Re: EN 010151 - Beacon Fen Energy Park

Boston Borough Council's - Deadline Six Submission – 12th January 2026.

The letter sets out Boston Borough Council (BBC) response to the Applicants Deadline 5 submissions for the above Project.

PART OF SLR

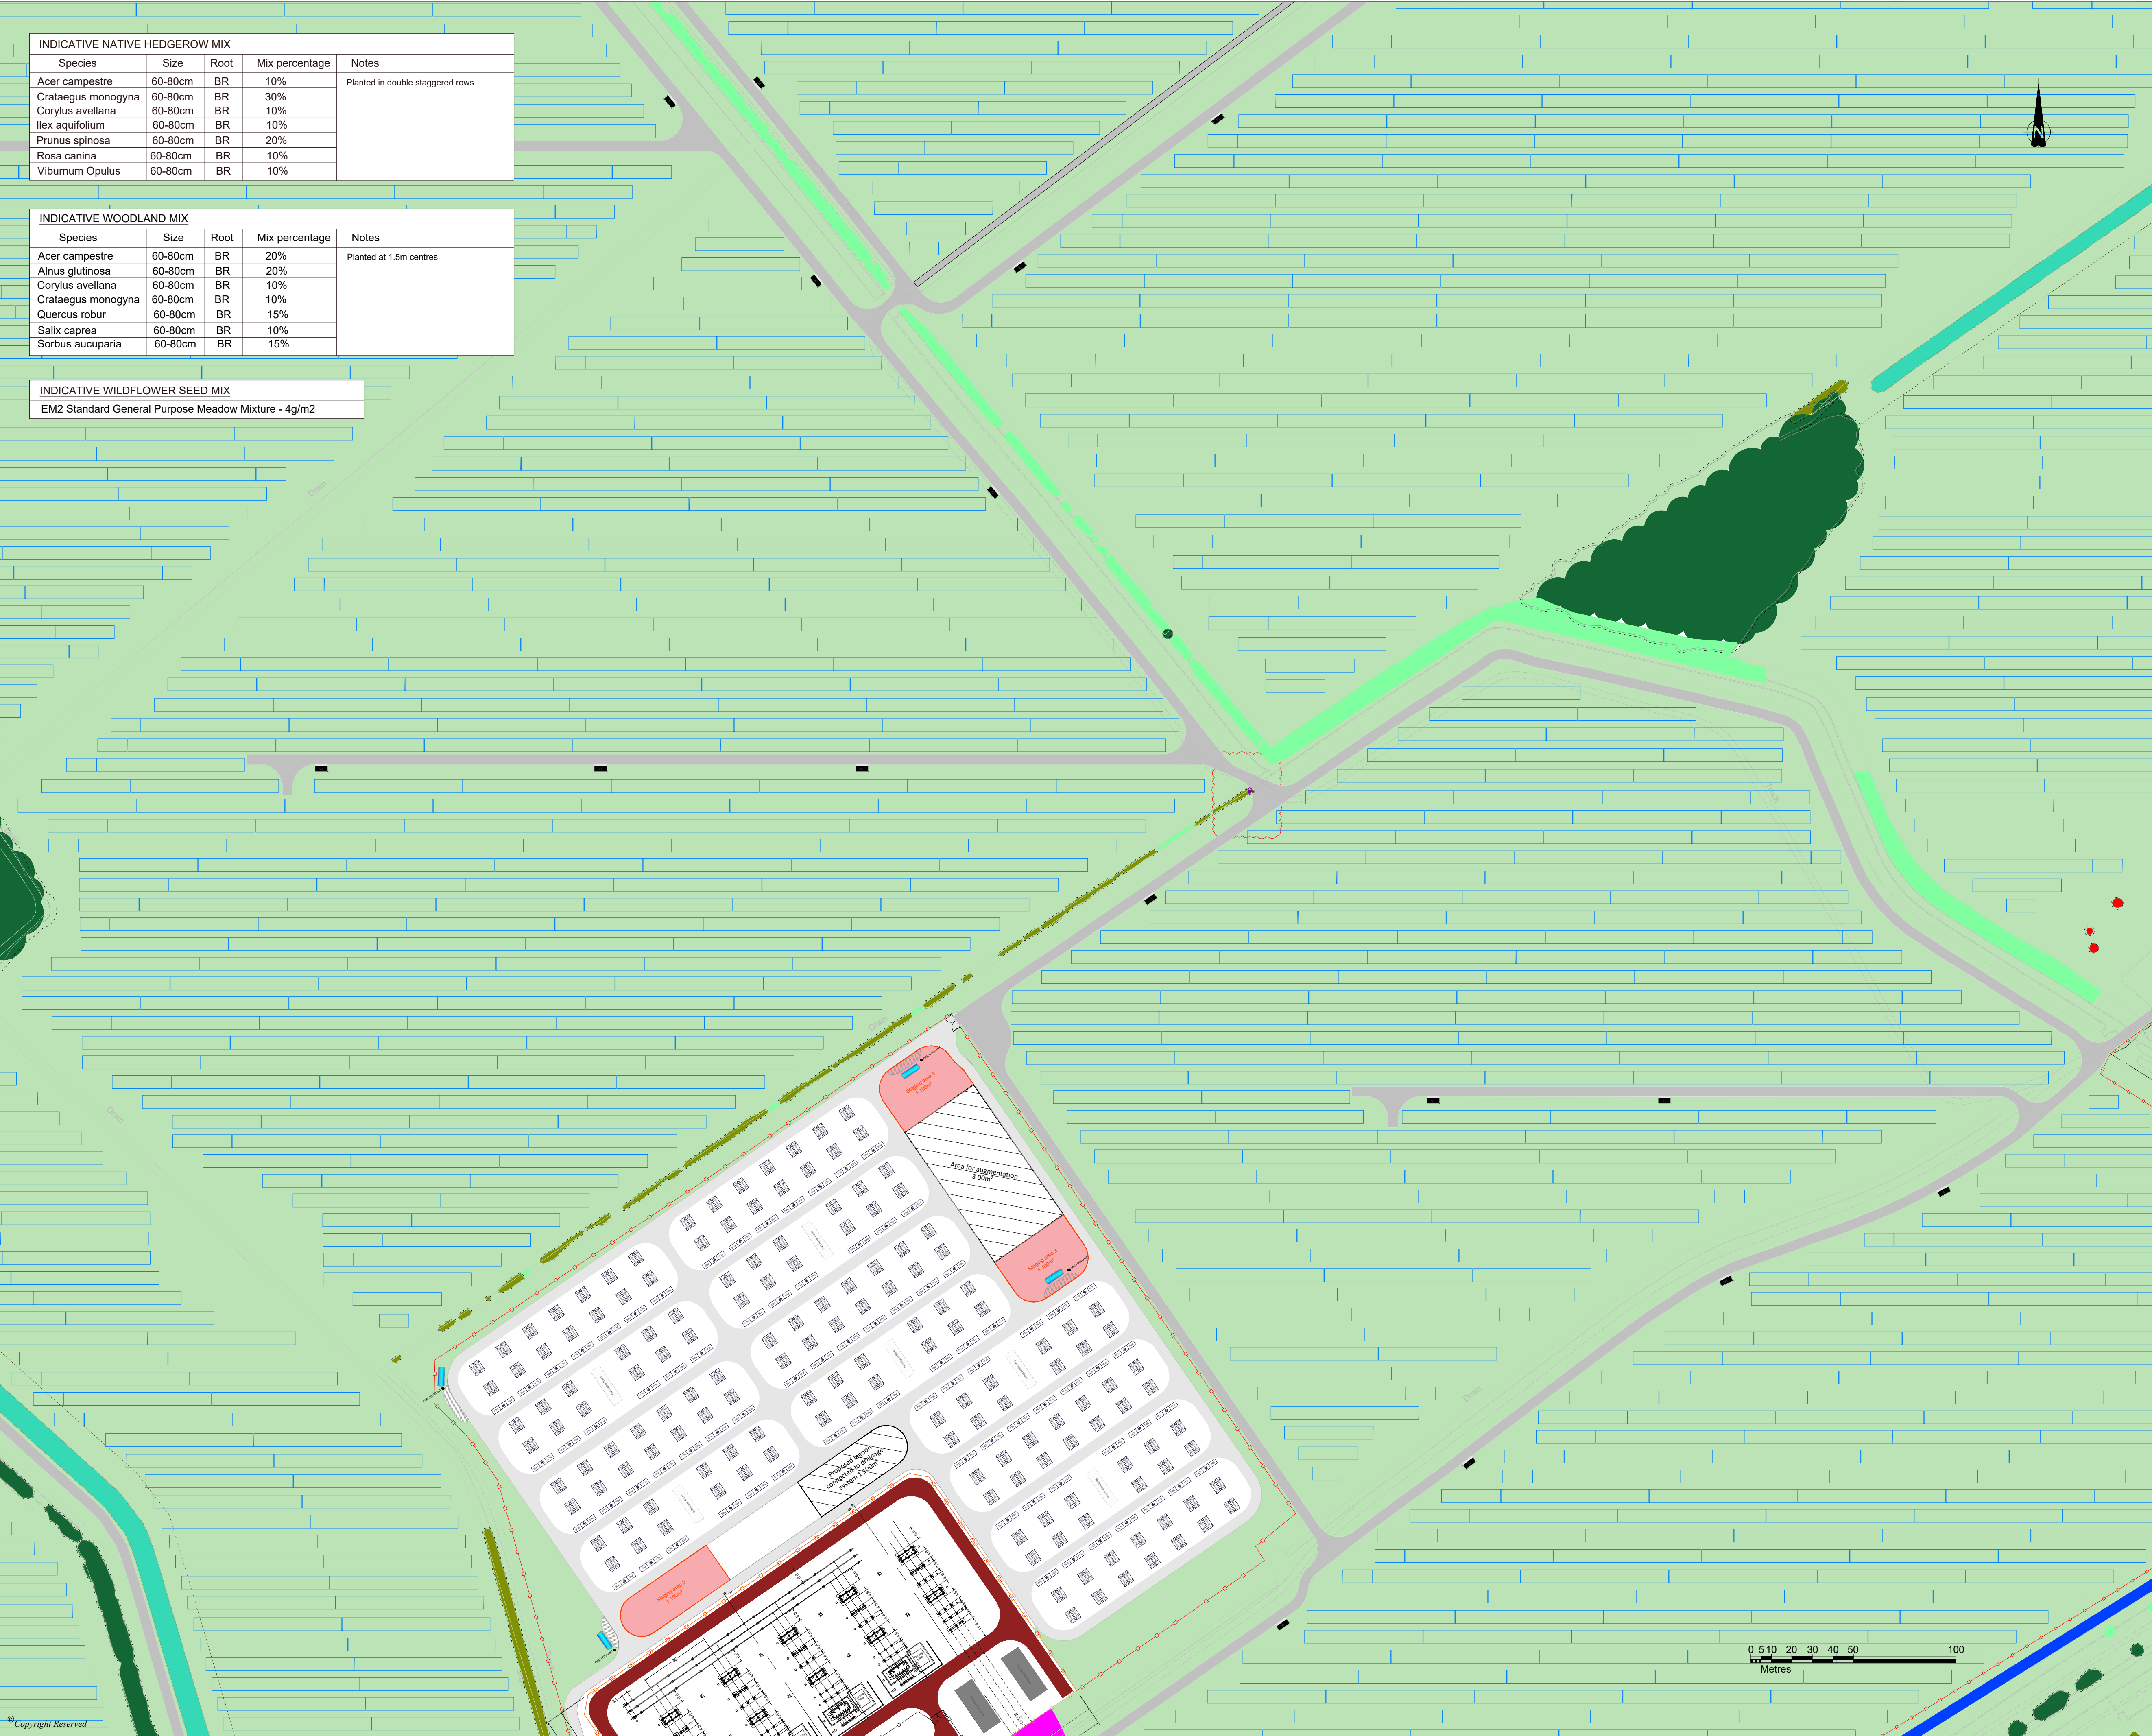
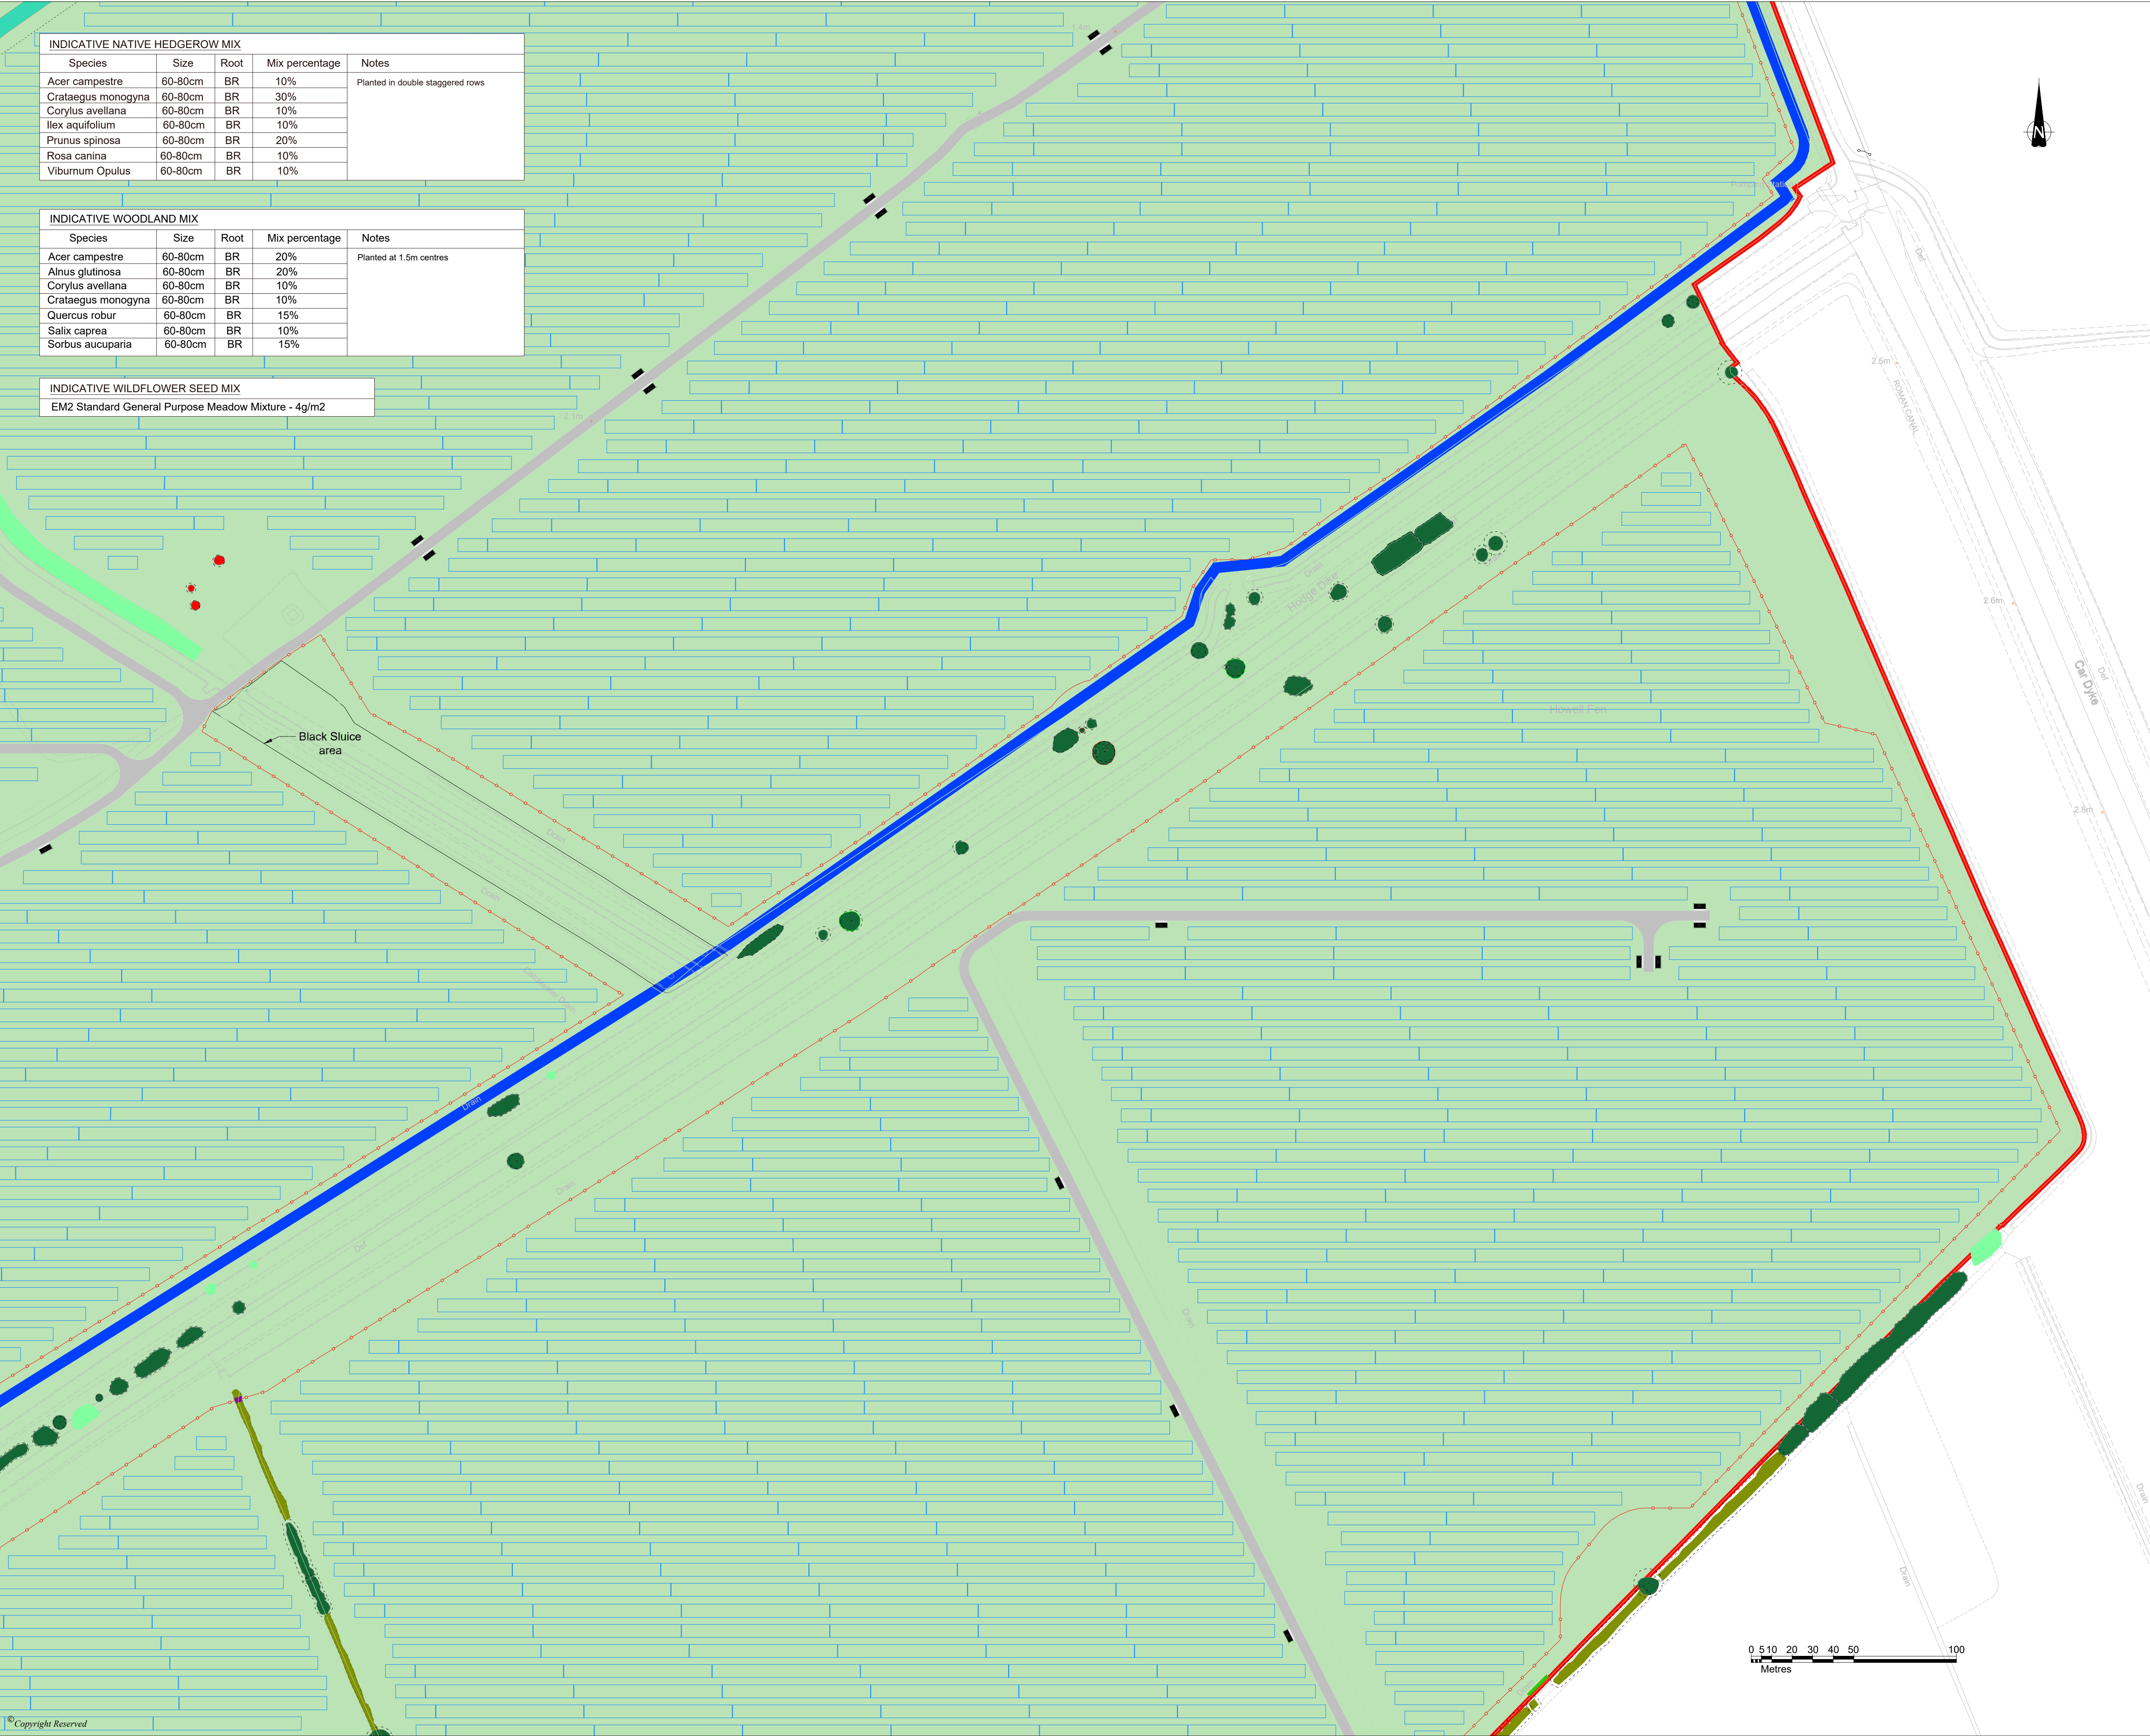
The Landscape Enhancement Measures included within the Change Request OLEMP (CR-016) and Change Request Landscape Strategy Plans (CR-021) at the existing Bicker Fen Substation are not included within the D5 OLEMP (REP5-026). BBC therefore requests that the OLEMP is updated to avoid confusion and understands that the Applicant will submit an updated OLEMP.

The Landscape Strategy Plan also references areas where vegetation is to be temporarily removed or temporarily lain to aggregate and, in both cases, reinstated. There is also reference to a restoration plan.
